Appeal Decision

Appeal Ref: APP/Z4718/D/24/3337682

9 Springwood Hall Gardens, Springwood, Huddersfield HD1 4HA

Drawing Title
Proposed Elevations

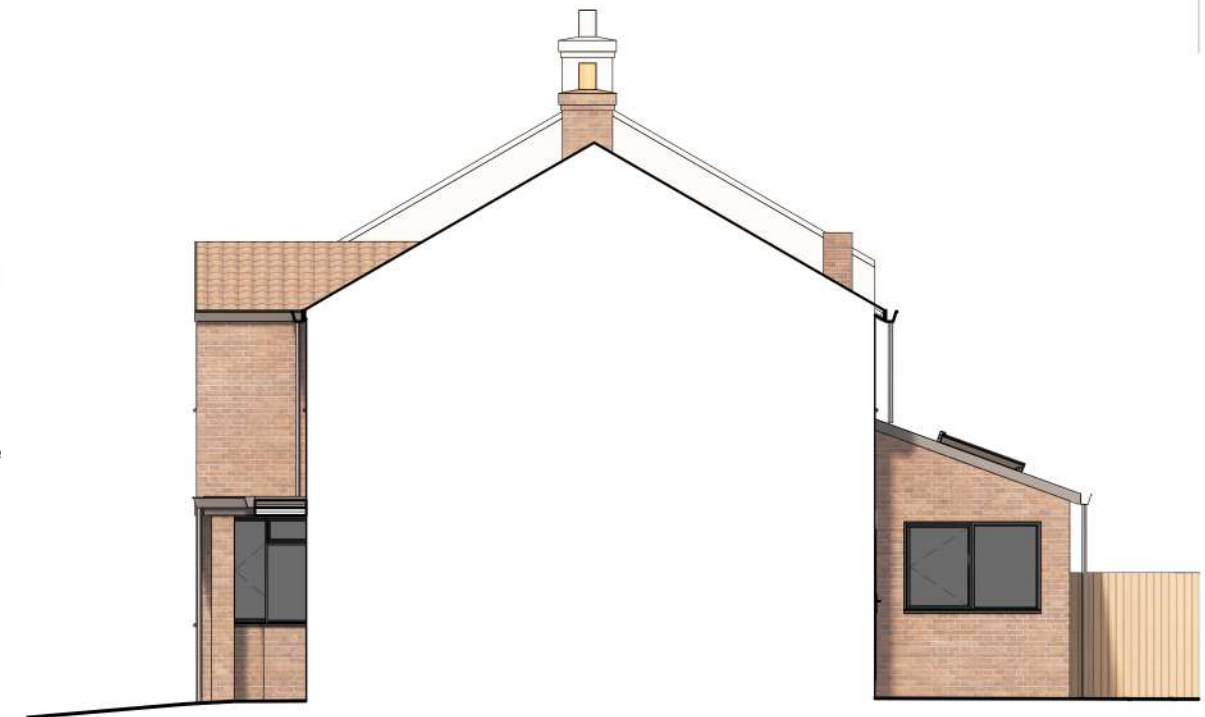
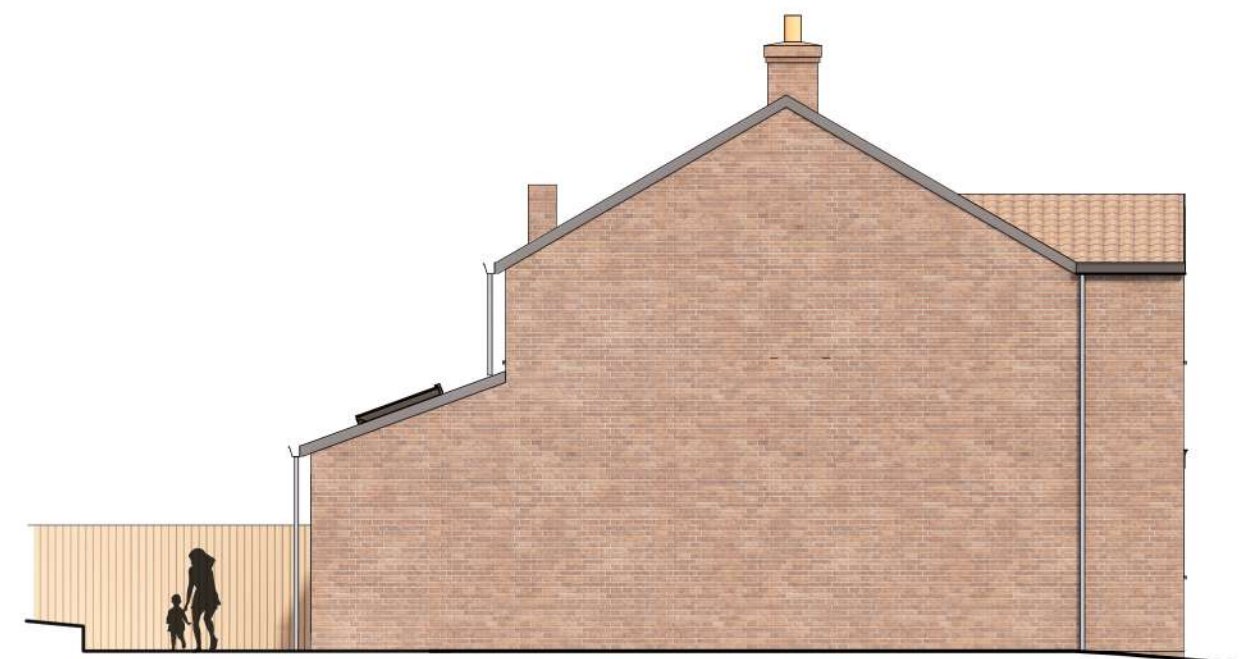
5. The proposed two storey extension projects forward from the front of the existing property. The House Extensions and Alterations SPD (2021) (the SPD) advises that two storey side extensions should not dominate the original house, be set back from the original frontage of the building, and should maintain a 1metre gap to the side boundary. The SPD also states that extending forward from the street's building line will only be appropriate in certain circumstances and will be assessed on the merits of the application.

8. The projection forward of the two storey extension is not incongruous with other built forms in the area. Although the extension encroaches upon the 1m gap between the appeal property and the shared boundary this is not unusual, the gap would still provide a degree of separation between the properties.

9. The Council do not raise concern with the proposed front canopy or the single storey rear extension in terms of character and appearance, from the details before me I do not disagree.

13. The proposed single storey rear extension includes a window facing towards the shared boundary with No. 11 Springwood Hall Gardens. A fence is partially erected beyond the rear elevation of the properties screening to a degree views between properties. There is potential for the window to overlook No. 11 despite the distance from the boundary.

14. The Appellant has confirmed it is their intension to erect a fence along the full boundary shared with No. 11. Subject to the design and height of the fence, which can be controlled by the imposition of a planning condition the proposed development would not harm the living conditions of the occupiers of No. 11 Springwood Hall Gardens.

Proposed Street Elevation

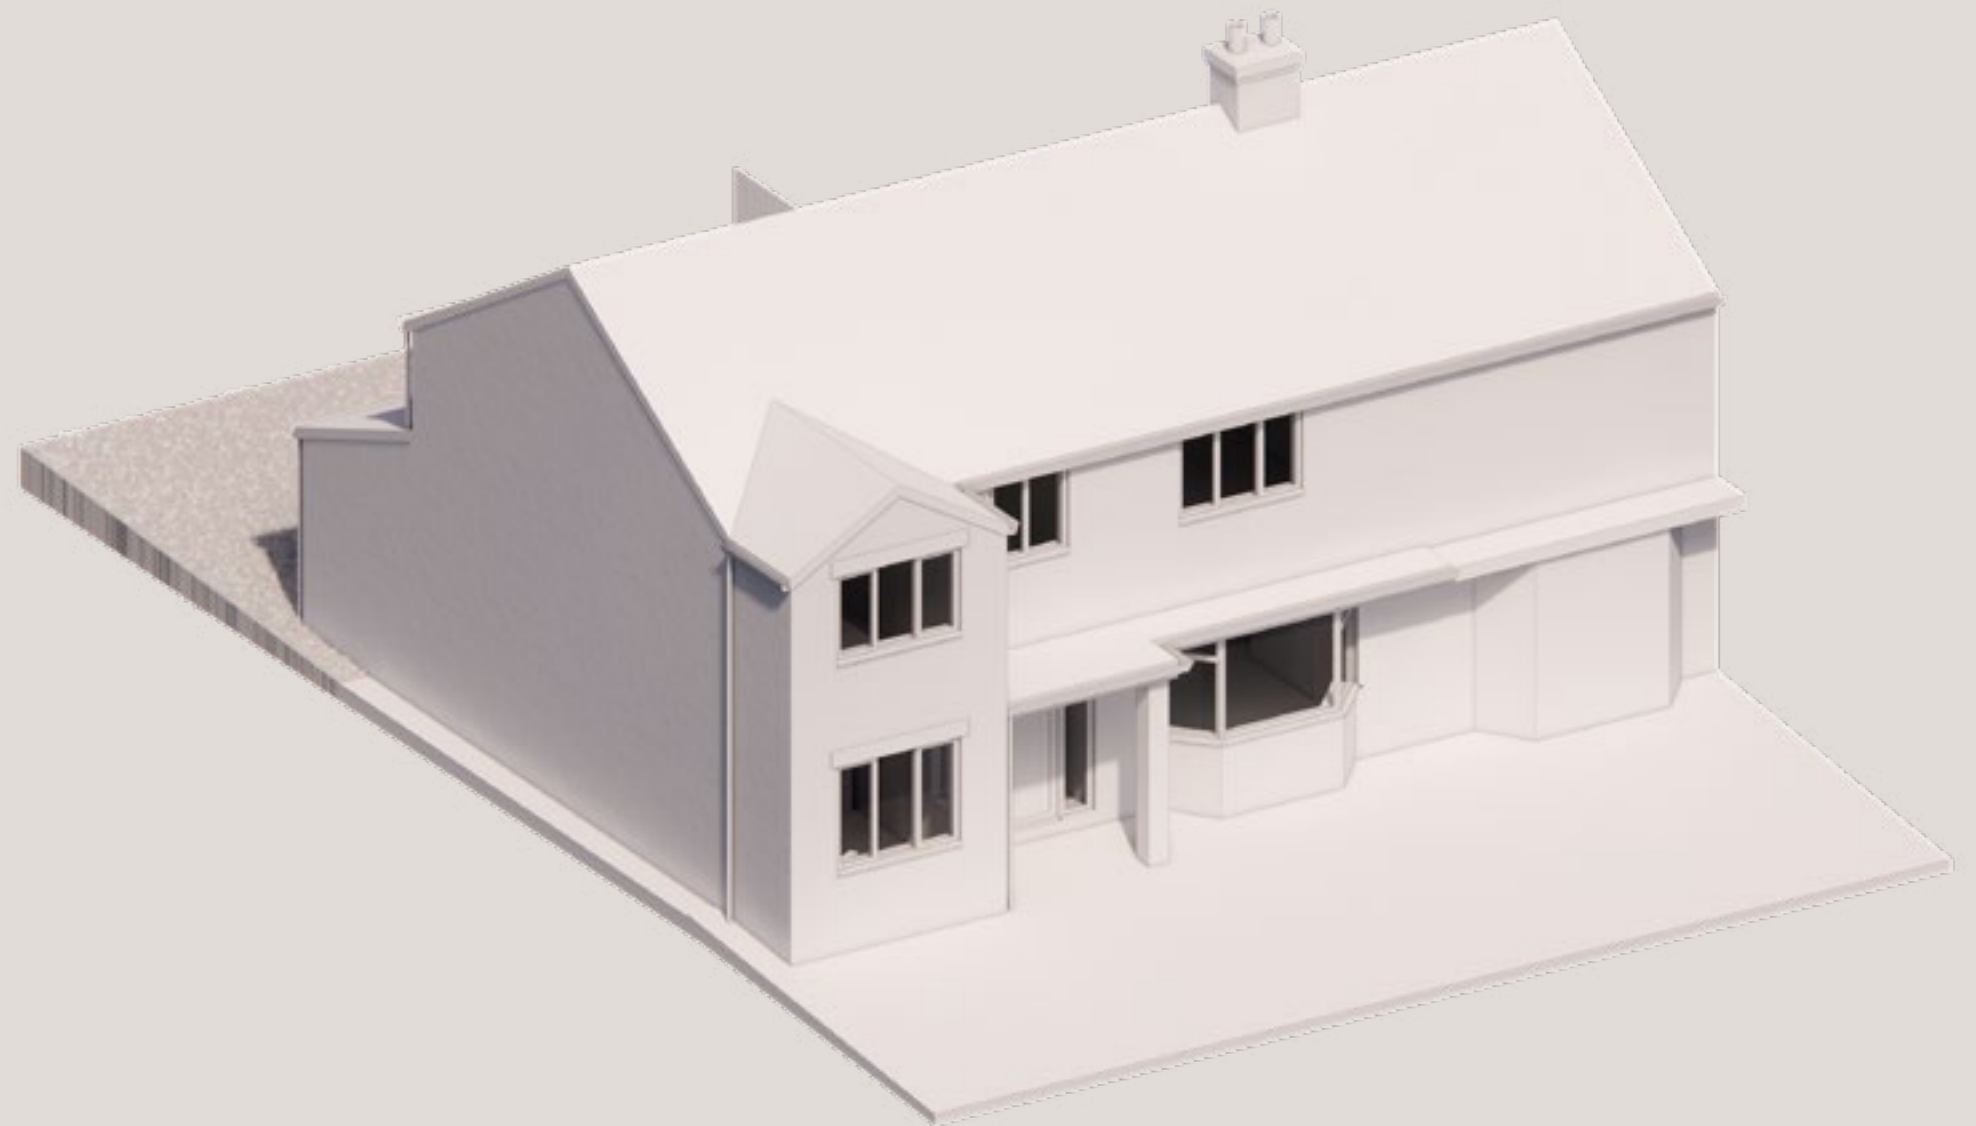
7. I observed during my site visit various extensions and alterations to properties in the area, including two storey side extensions which project forward of the principal elevation. The Council does not afford this significant weight. I disagree, whilst some extensions are on different house types, and some may have been approved prior to the adoption of the SPD, they form part of the character and appearance of the area.

10. Whilst the proposed development would reduce the symmetry of the appeal site and the attached neighbouring property, No. 11, given the varying forms of development within the immediate area, I find that the proposed development would not harm the character and appearance of the host property and area in general.
